From: Finlay Gardner <Finlay.Gardner@arun.gov.uk>
Sent: 10 February 2021 11:38
To: Planning.Responses <Planning.Responses@arun.gov.uk>
Subject: FW: Planning Query

Please attach to FP/10/21/HH as call to committee

sheet 2 a of 3

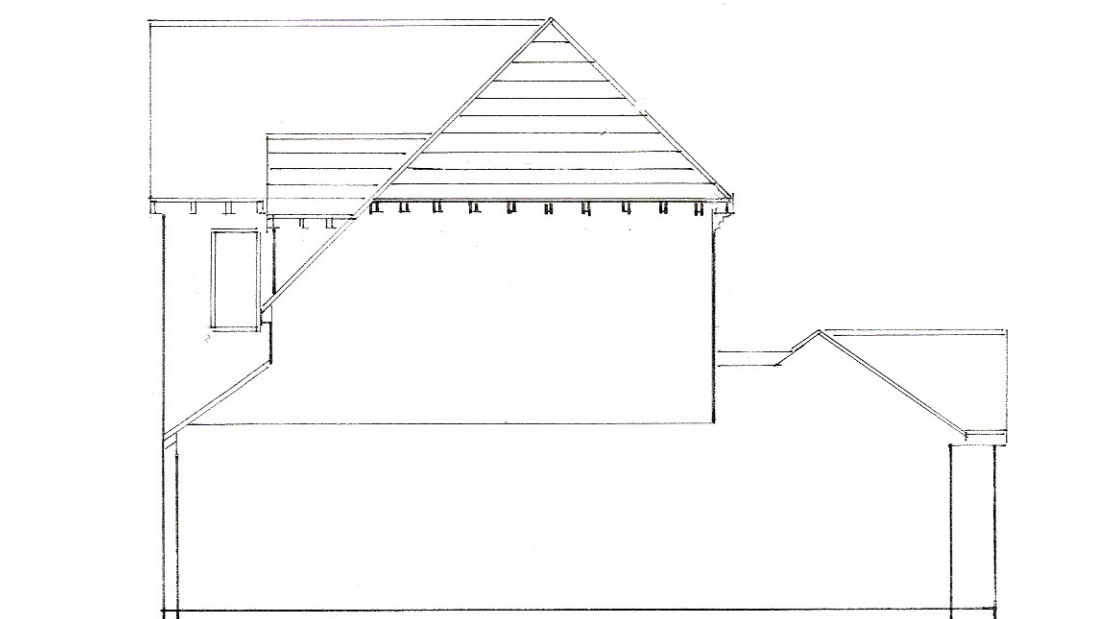
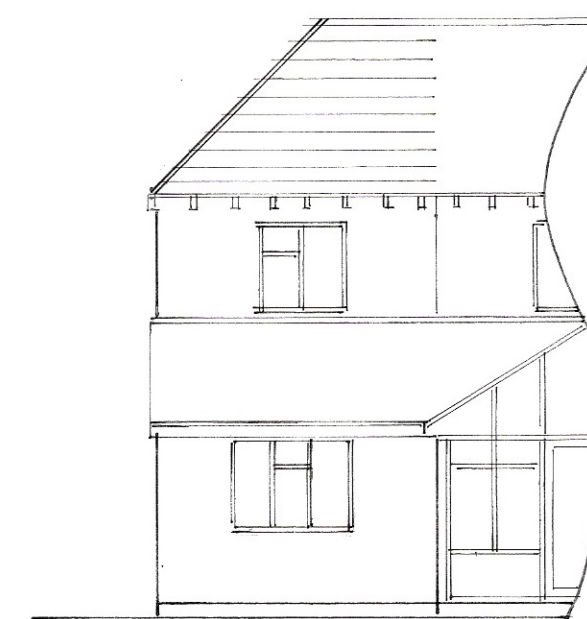
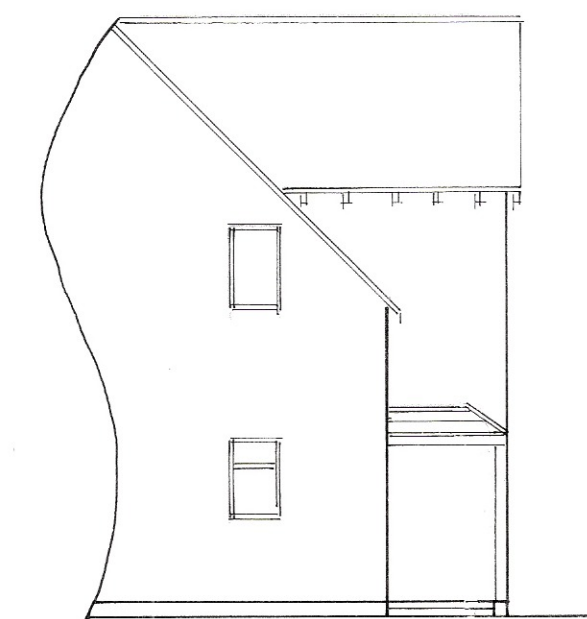
However I still feel it is in breach of the 1m restriction at 2nd floor level and is certainly detrimental to the street seen with over powering the bungalow which was never the intention. No other property in the area has been given permission to proceed to do this and I could find none in existence.

With this being allowed it would be very detrimental to the property into the future and not appear appealing from the road view point.

The new proposal does not have a 1m gap at first floor. However they have changed the roof from a gable end to a hipped roof in order to reduce the impact on the neighbouring property. With the reduction in the roof I believe there is not sufficient grounds to refuse the application on the impact on the neighbouring property.

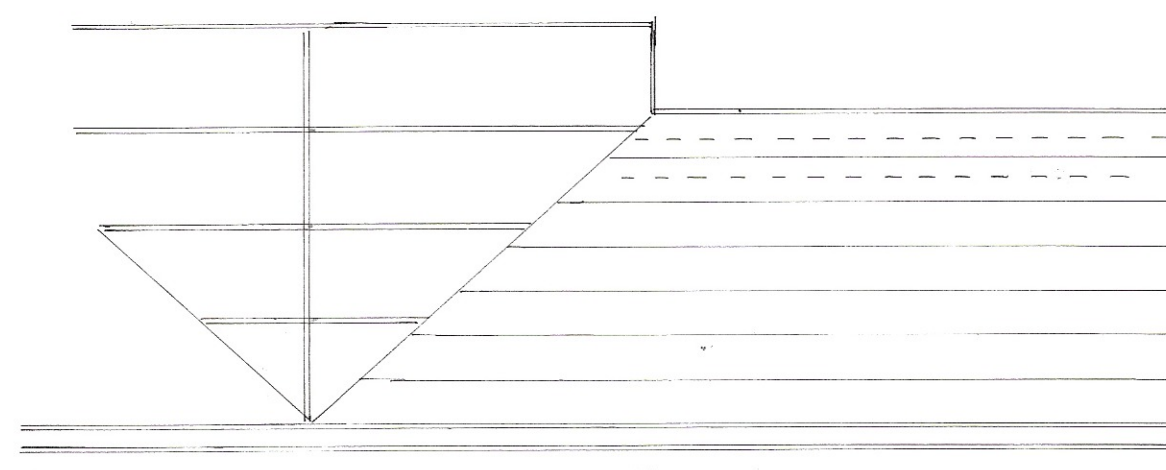
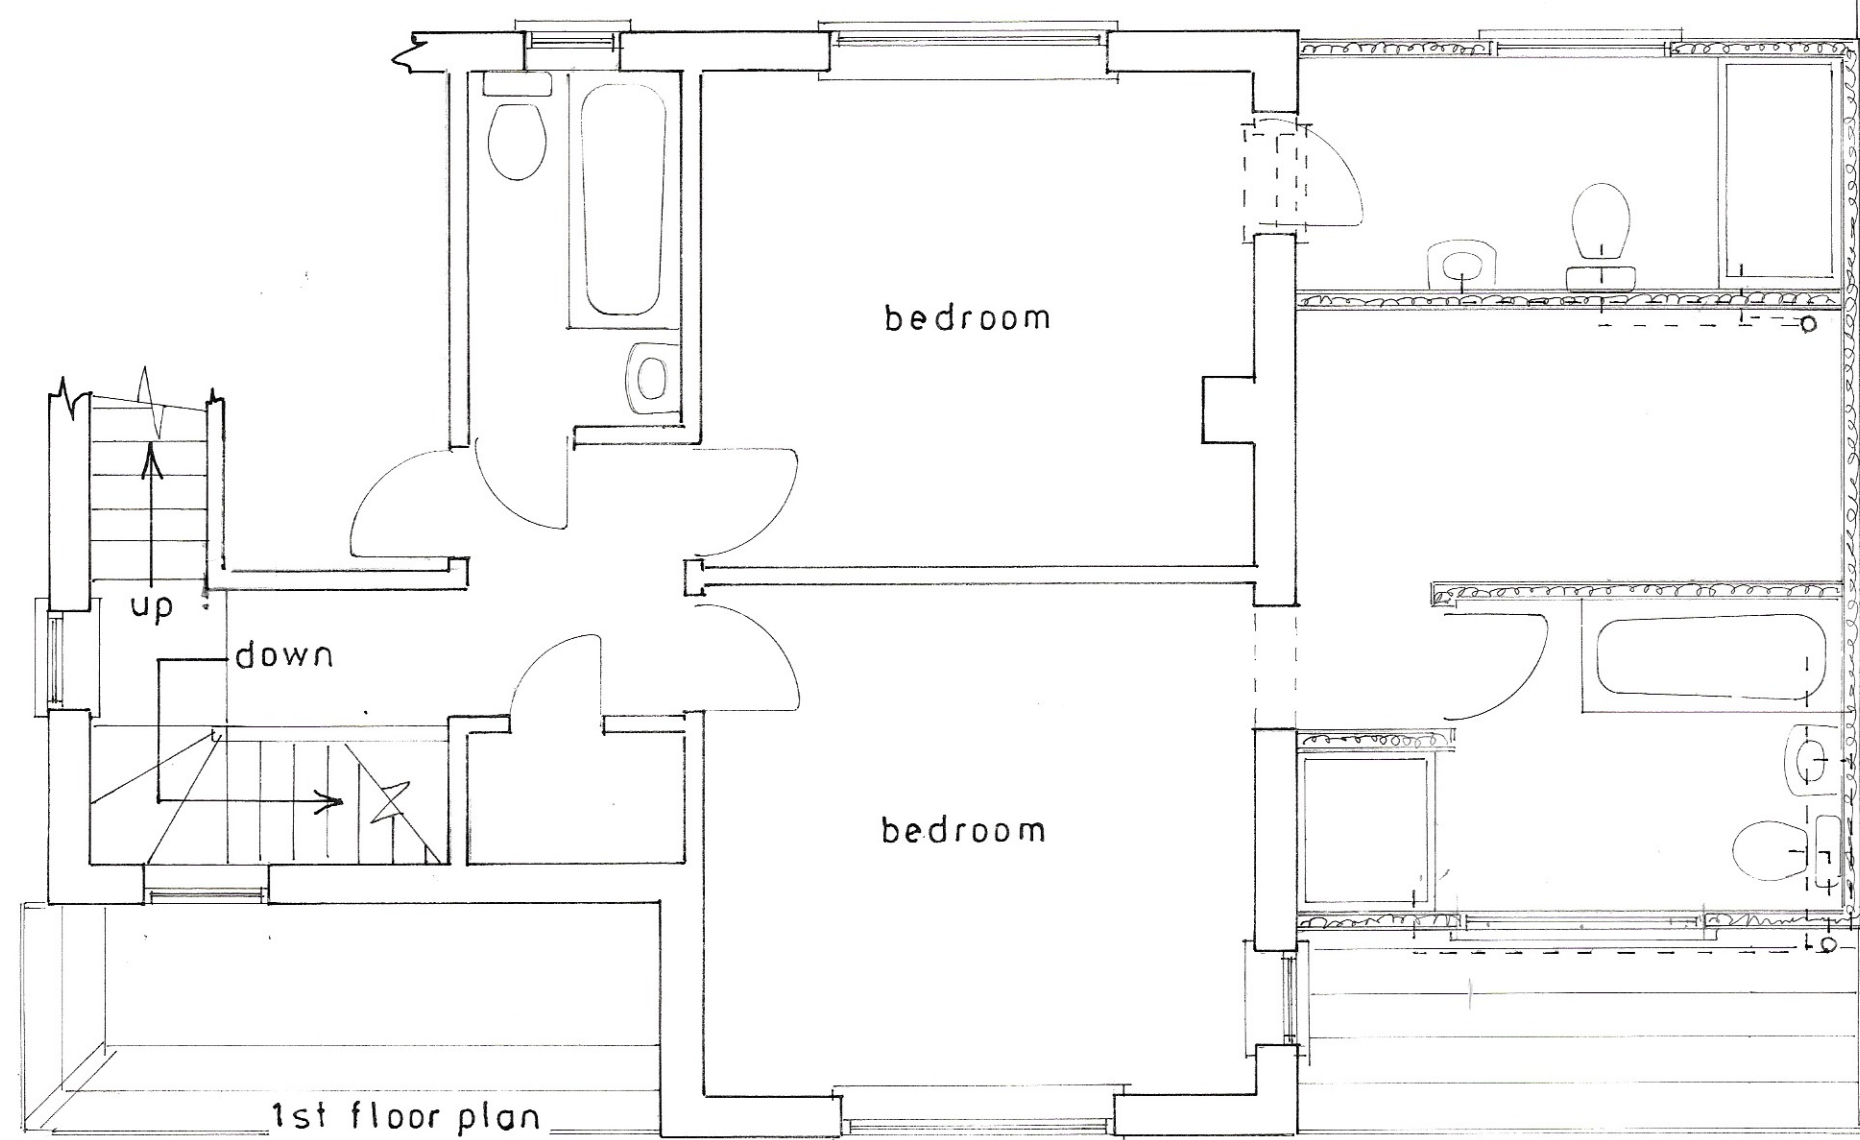
It will still be dwarfing the bungalow and with the house on the other side which has maintained a 1m back from the boundary and still towers over the bungalow I feel it needs protecting.

I am struggling to see the difference with these drawings,
I still cant see the 1m back from boundary at 2nd floor level? Have I got this wrong? I cant see boundary measurements.

Can you confirm the building shows 1m back at 2nd floor level?
